February 5, 2015

Re: Civic Center Signage Master Plan, Second Amendment
Project ID: #2012-505

Exterior Signage Master Plan Rev. 02-27-14

Additional Proposed Changes Rev 02-05-15

Southeast Entrance

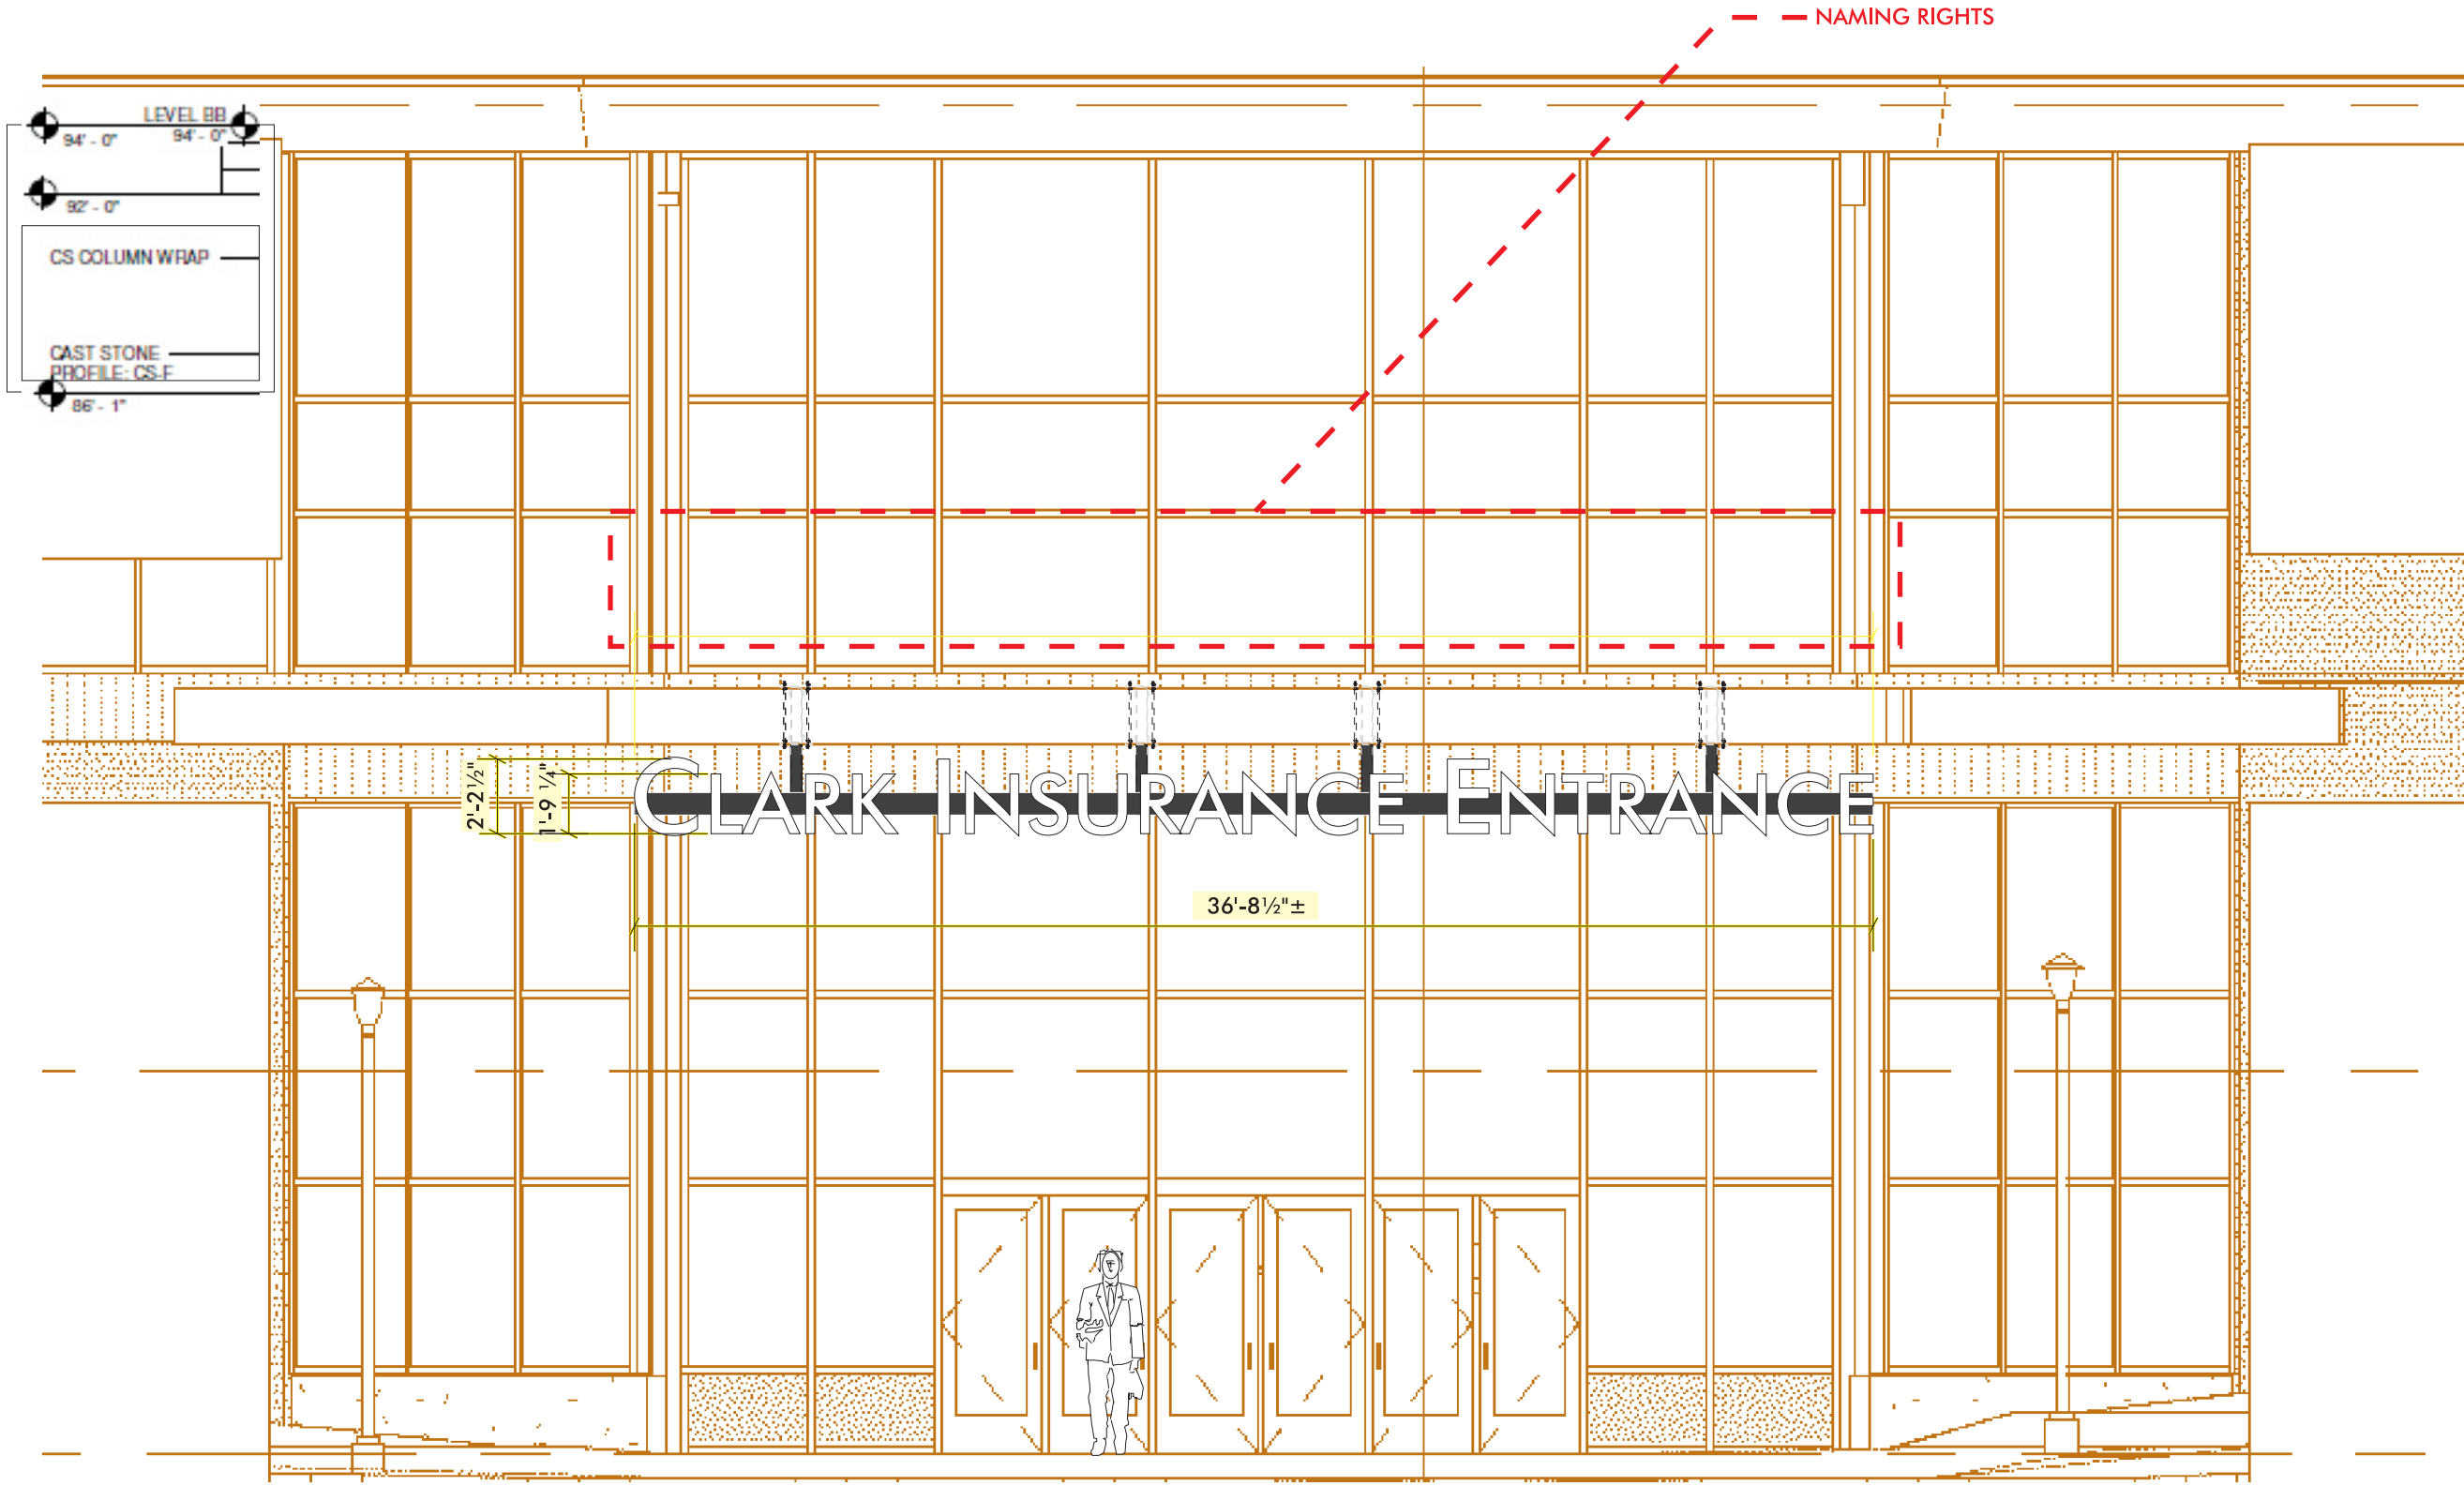
Specifically you are requesting to replace a sign proposed above the proposed marquee on the southeast entrance of the Civic Center with a sign on the southeast side of the building, where the current Cumberland County Civic Center sign is located. You propose to retain a sign of the same size at that location, with the new name of the building and a lighthouse. While the name of the arena is the Cross Insurance Arena, you are not proposing using the Cross Insurance logo at that

location, instead proposing a lighthouse with a second accent color. You have stated that the reason you need this amendment to the signage master plan is due to the need to identify the building from a distance for visitors. The Materials for the proposed sign are Aluminum and Acrylic channel letters which will be internally illuminated via LEDs.

You are not proposing a sign above the cornice of the building, nor are you proposing a sign any larger than the one already located at that location. The number of signs remains the same based on the removal of the proposed sign at the southeast entrance, which, while smaller in size, would be visible from a similar direction.

For these reasons, I approve that substitution with one condition. The metal band on which the marquee is eventually proposed for the southeast entrance will need an interim treatment while the plans to install a marquee are completed. Please submit a plan for an interim treatment for that metal band for Planning Authority review and approval under the master signage plan.
